Appeal Decision

Appeal Ref: APP/R5510/W/21/3283166

West End Road, Hillingdon, London HA4 6LA Easting: 509830 Northing: 186389

- The appeal is made under section 78 of the Town and Country Planning Act 1990 against a refusal to grant approval required under Article 3(1) and Schedule 2, Part 16 Class A of the Town and Country Planning (General Permitted Development) (England) Order 2015 (as amended).
- The appeal is made by CK Hutchison Networks (UK) Ltd against the decision of London Borough of Hillingdon.
- The application Ref 76560/APP/2021/2636, dated 2 July 2021, was refused by notice dated 20 August 2021.
- The development proposed is the installation of 15 metre Phase Street Pole and GPS module mounted at top of pole, wrap-around cabinet at base, equipment cabinet, transmission cabinet, commscope bowler cabinet and associated ancillary works.

Title: 265 PROPOSED SITE ELEVATION

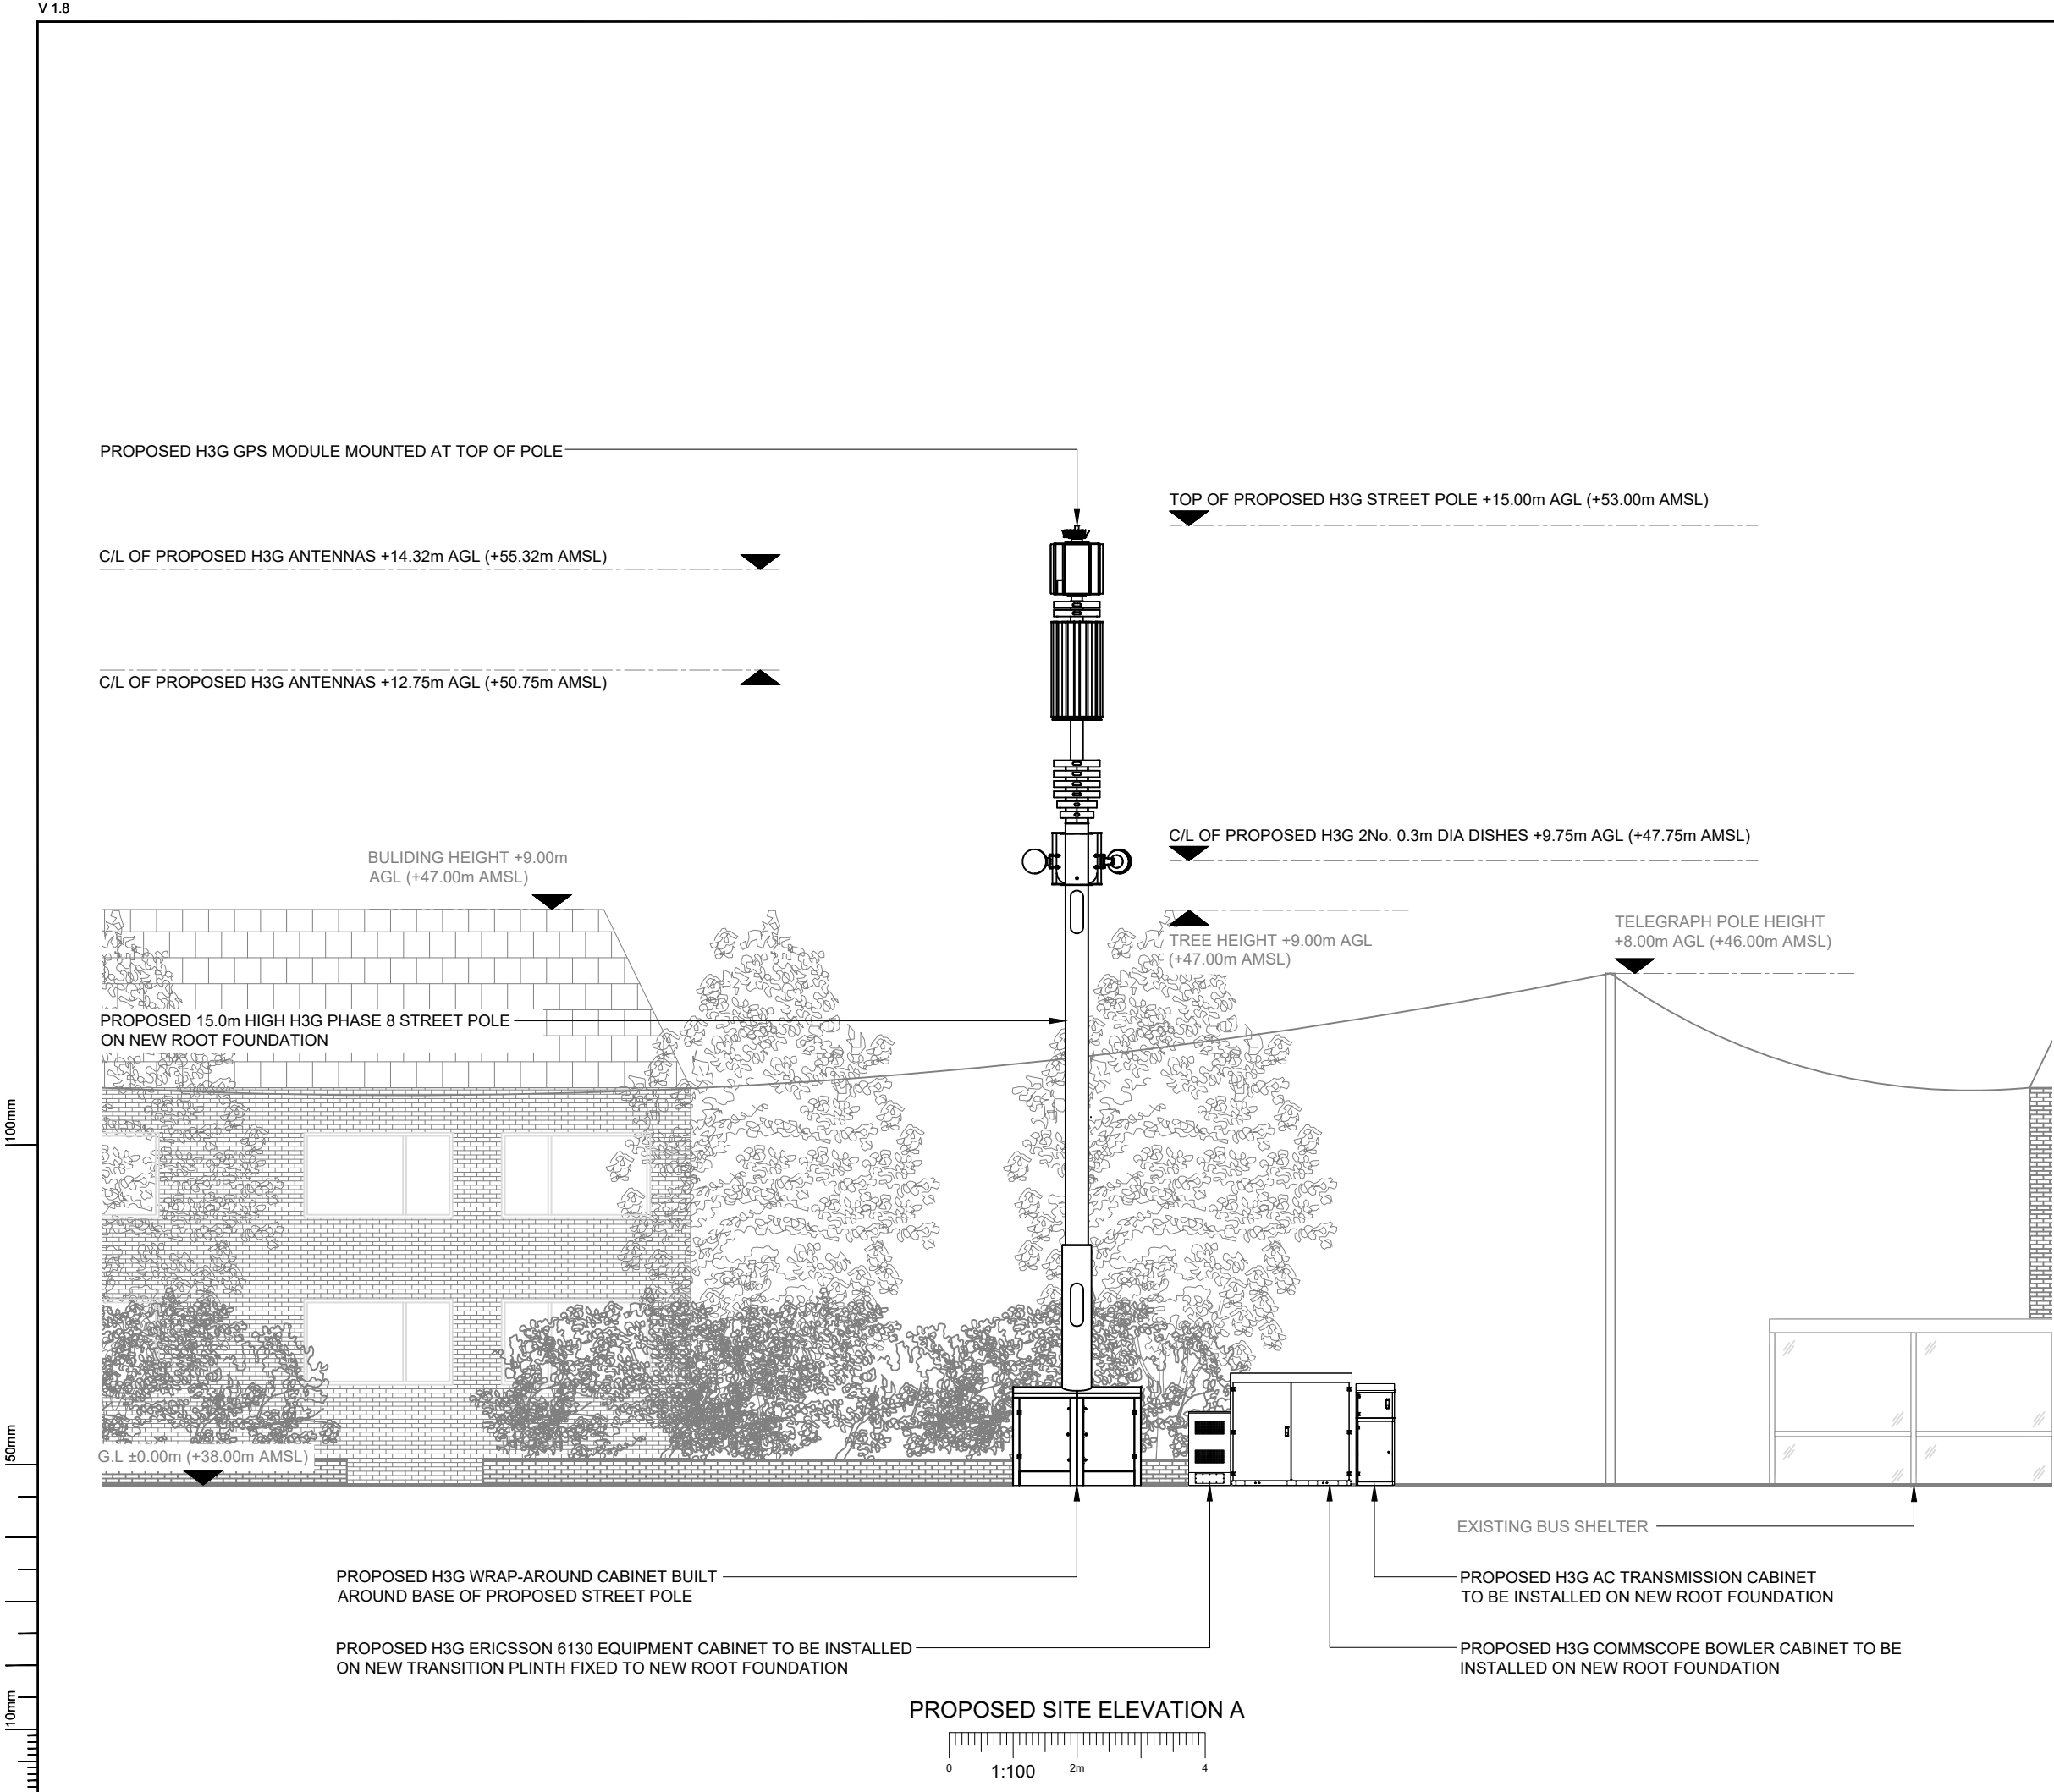
6. West End Road is a main arterial route into and out of Ruislip. The proposed installation would occupy a prominent position adjacent to this road, and it would also be prominent in views taken along Herlwyn Avenue towards it. The surrounding area is characterised predominantly by the arrangement of residential dwellings along both the main road and those streets that lead from it. Ruislip Nursing Home, which is referred to as a locally listed building, is also close to the appeal site. Typical of a well-established urban area there are items of street furniture present in the locality including a bus shelter, equipment cabinets, telegraph poles and lighting columns, along with mature street trees.

7. The proposed mast would however substantially exceed the height of similar structures such as telegraph poles and streetlights, and it would be much bulkier in appearance. From views both along West End Road and Herlwyn Avenue the proposal would have a dominant visual impact due to its height and overall bulk, and one that would appear at odds with its surrounding environment and the more understated existing street furniture. It would, as a result of its height, appearance and positioning, appear as an incongruous and visually harmful addition to the street scene. The collection of its associated cabinets would further compound its visual impact and would create clutter in comparison to the existing cabinets and other street furniture that is more widely dispersed along the road.

8. I have not been provided with details relating to the local listing of Ruislip Nursing Home such as how the property came to be locally listed and for what reasons. Irrespective of this, it is an attractive period property which contributes positively to the character and appearance of the street scene. The proposal would be seen collectively in certain views of the nursing home taken from West End Road, and due to the visual dominance of the proposed installation it would compromise such views, drawing attention away from the locally listed building. This would cause harm to the setting of the building, and it is a consideration that further weighs against the siting and appearance of the proposed installation.
